From: Joney Ramirez <[REDACTED]>
Sent: 29 November 2019 12:46
To: [REDACTED]
Cc: Karl Roberts <[REDACTED]> Nick Laister <[REDACTED]> nic burrell <[REDACTED]>
Subject: A/100/19/PL - Arundel Acre - response to Highways England
Importance: High

A response has been received from Highways England requiring more information on the proposal for Arundel Acre, Angmering (application ref. A/100/19/PL) and we would like to address this request as follows.

Appendix D – Drawing No: JNY10317/02

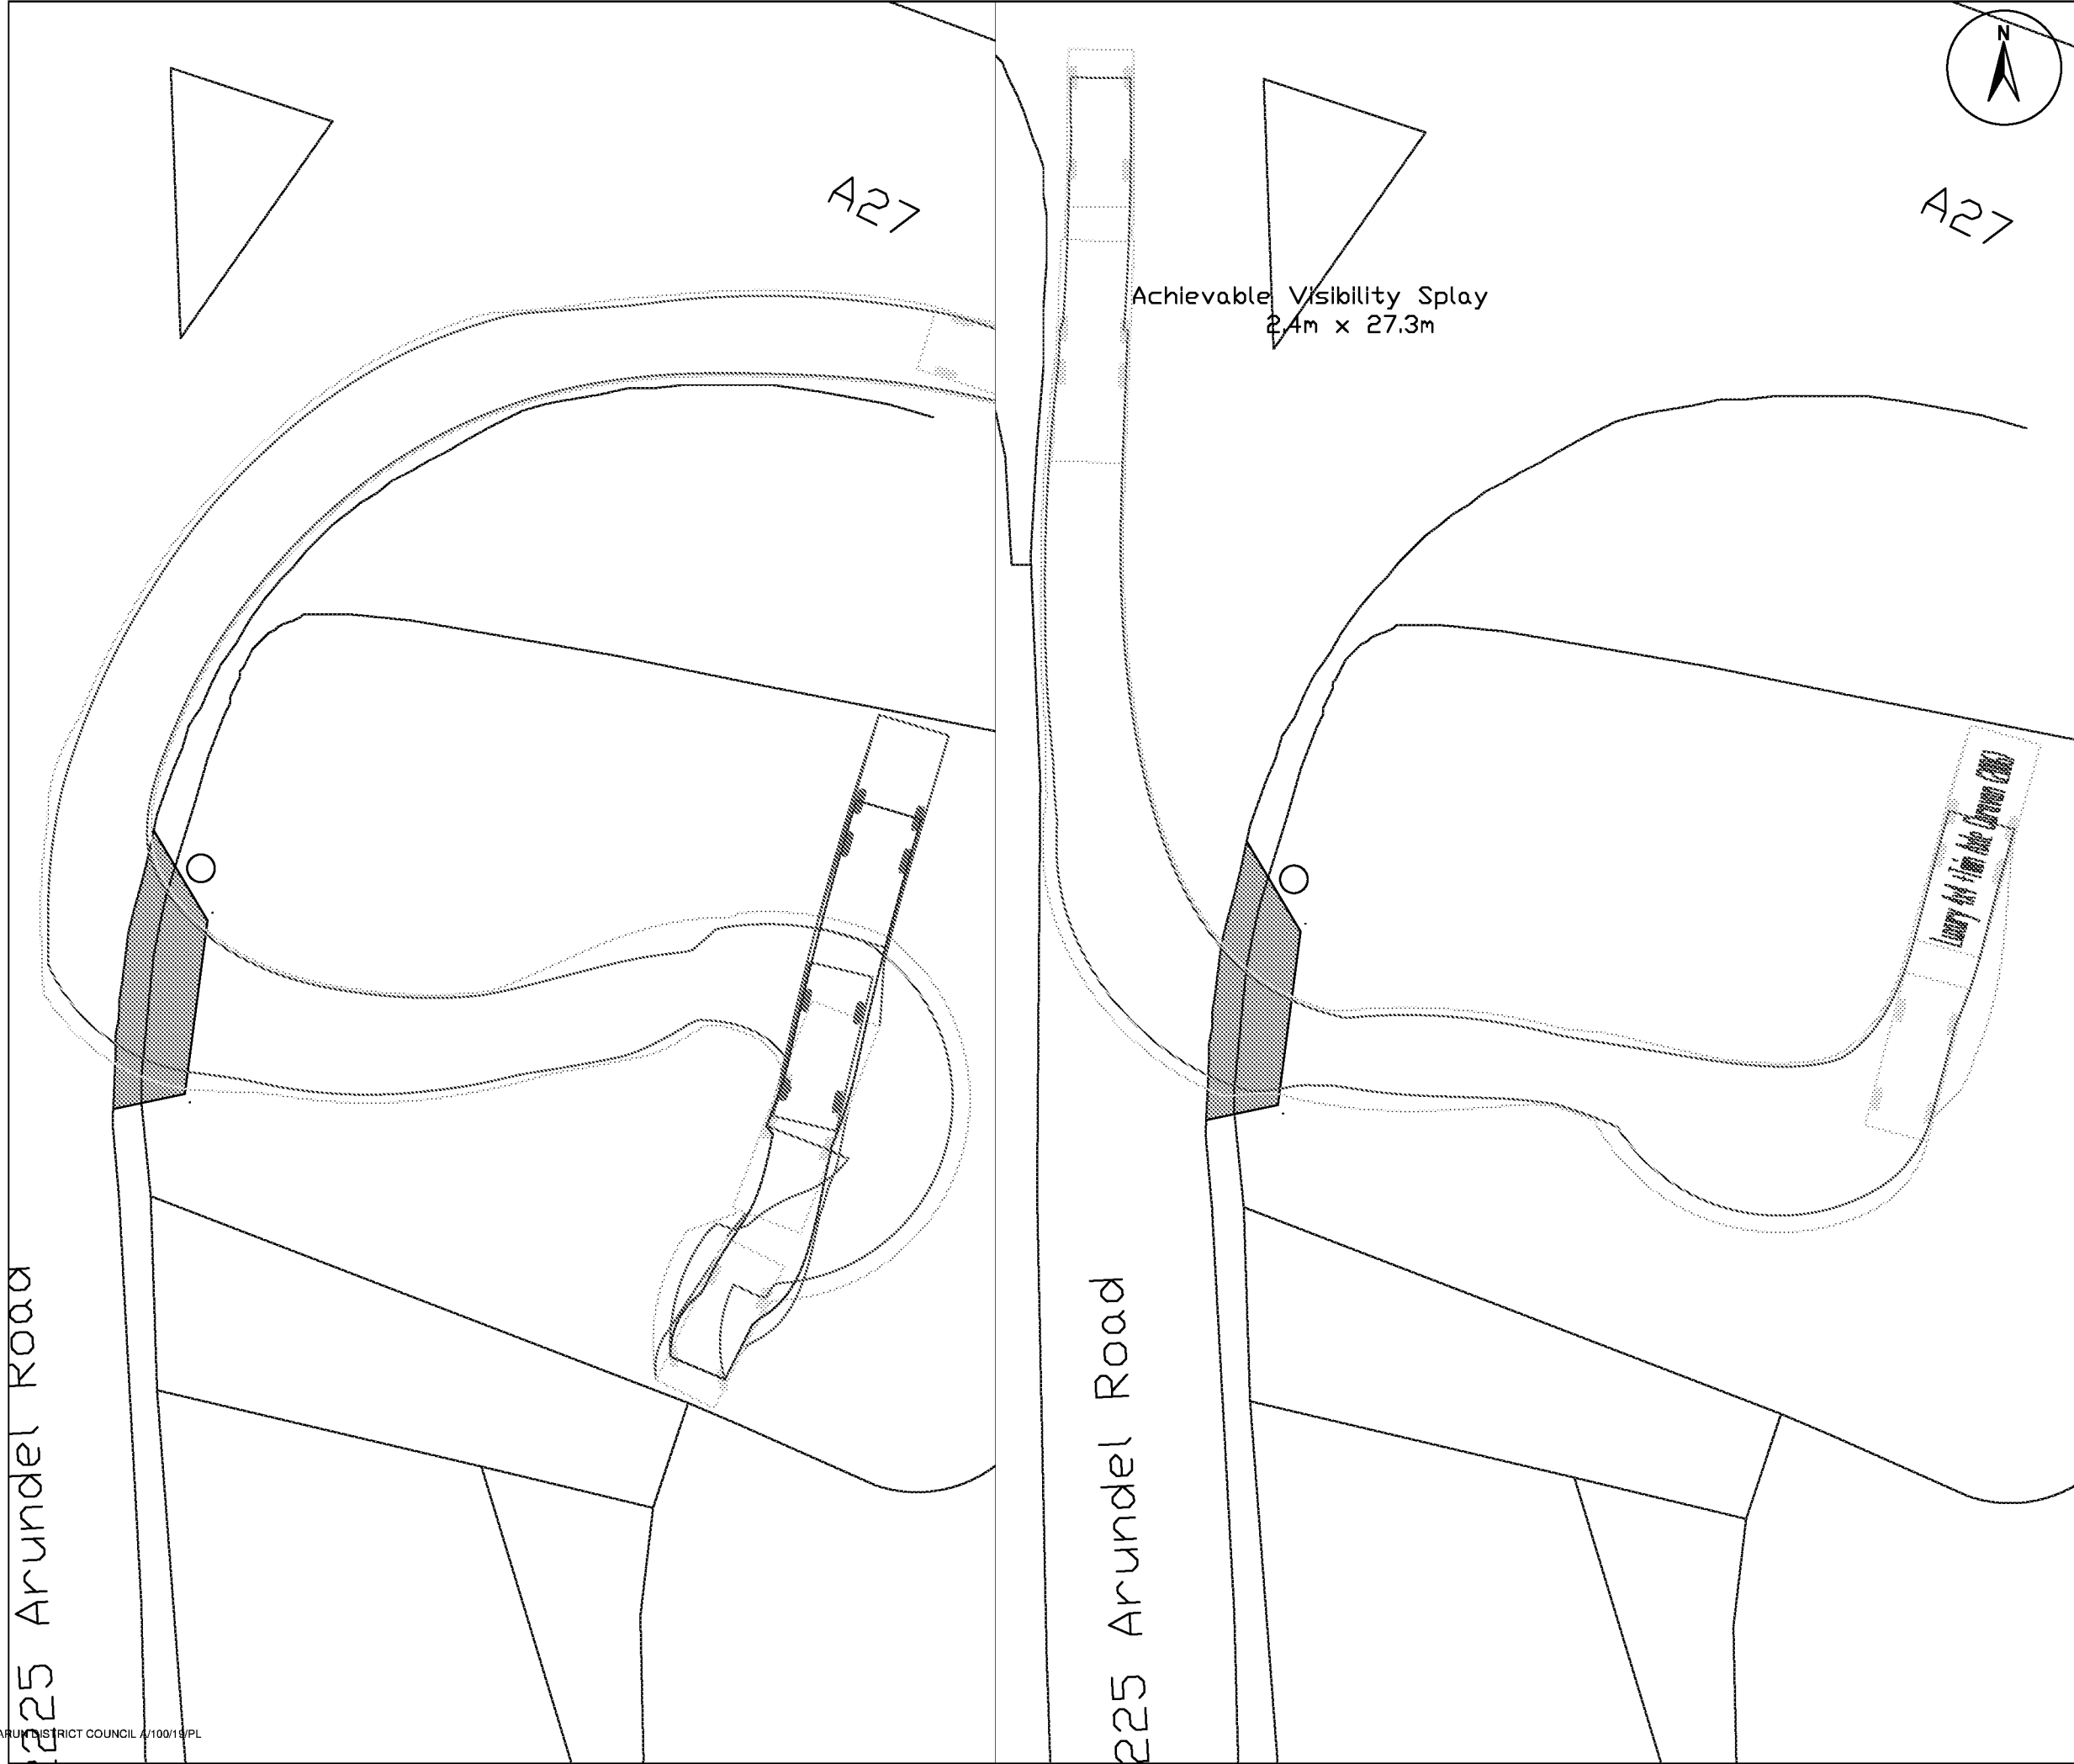
We also attach an updated vehicle tracking diagram (Drawing No. JNY10317/02) demonstrating that vehicles will be capable of entering and leave the site on forward gear.
